# COUNTY COUNCIL'S RESPONSE TO CONSULTATION ON THE FOLLOWING DEVELOPMENT PROPOSAL

**Application No:** 20/03404/F

**Location:** Unit B, Symmetry Park, Morrell Way, Ambrosden, OX26 6GF

**Response date:** 6<sup>th</sup> January 2021

Drawing file: C-13482-HYD-00-ZZ-DR-C-7000_P03 - Proposed drainage strategy Sheet 1 of 2.pdf

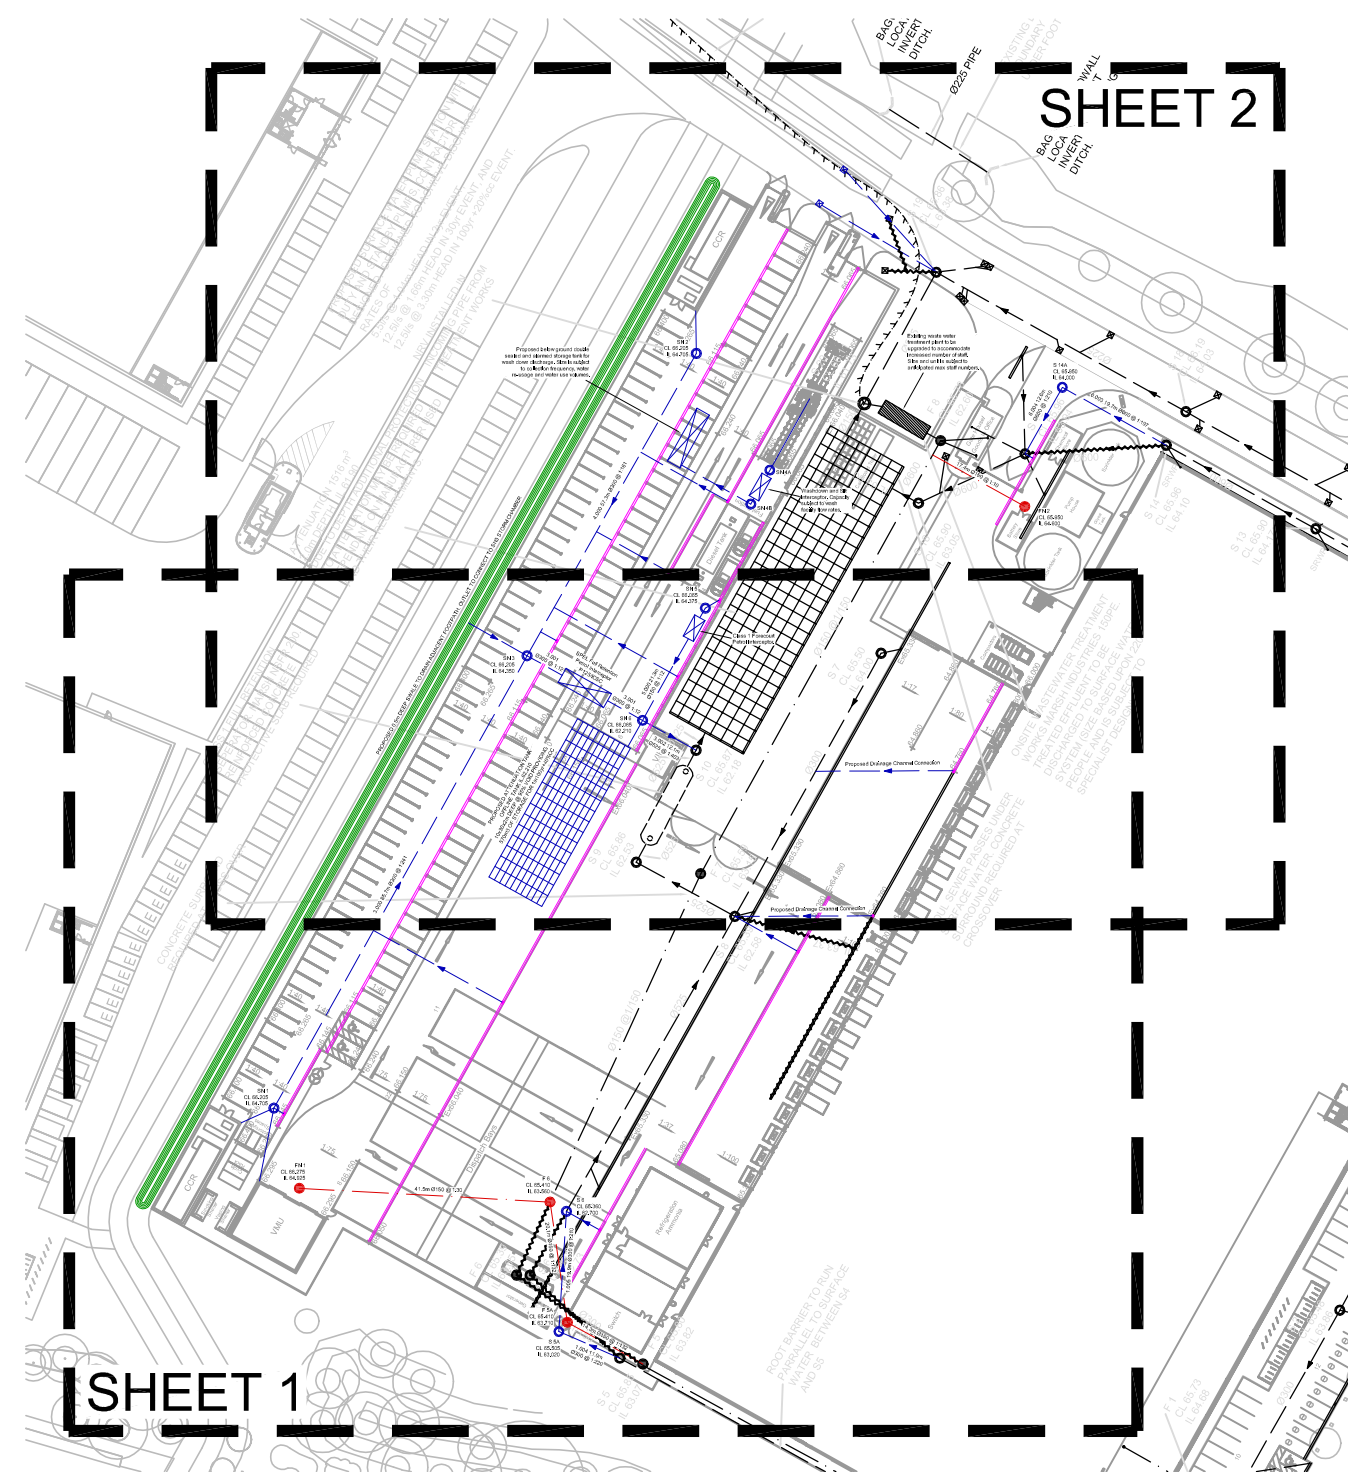
- No exceedance route or contingency shown in case of pump failure.
- There is no evidence of areas used in the calculation, such as impermeable and permeable areas.
- The access road to office car park is covered within the red line boundary but has not been included as part of the drainage strategy model in either of the drawing.
- There is no evidence suggesting that the existing areas have been taken into account during hydraulic modelling/calculations.

Proposed development needs a water quality assessment in accordance with Section 4 and Section 26 of SuDS Manual.

Proposed development must meet local standards, L19, "At least one surface feature should be deployed within the drainage system for water quality purposes, or more features for runoff which may contain higher levels of pollutants in accordance with the CIRIA SuDS Manual C753. Only if surface features are demonstrated as not viable, then approved proprietary engineered pollution control features such as vortex separators, serviceable/ replaceable filter screens, or pollution interceptors may be used"

A compliance report is required in line with the [Local Standards and Guidance for Surface Water Drainage on Major Development in Oxfordshire](#) which addresses the above issues.
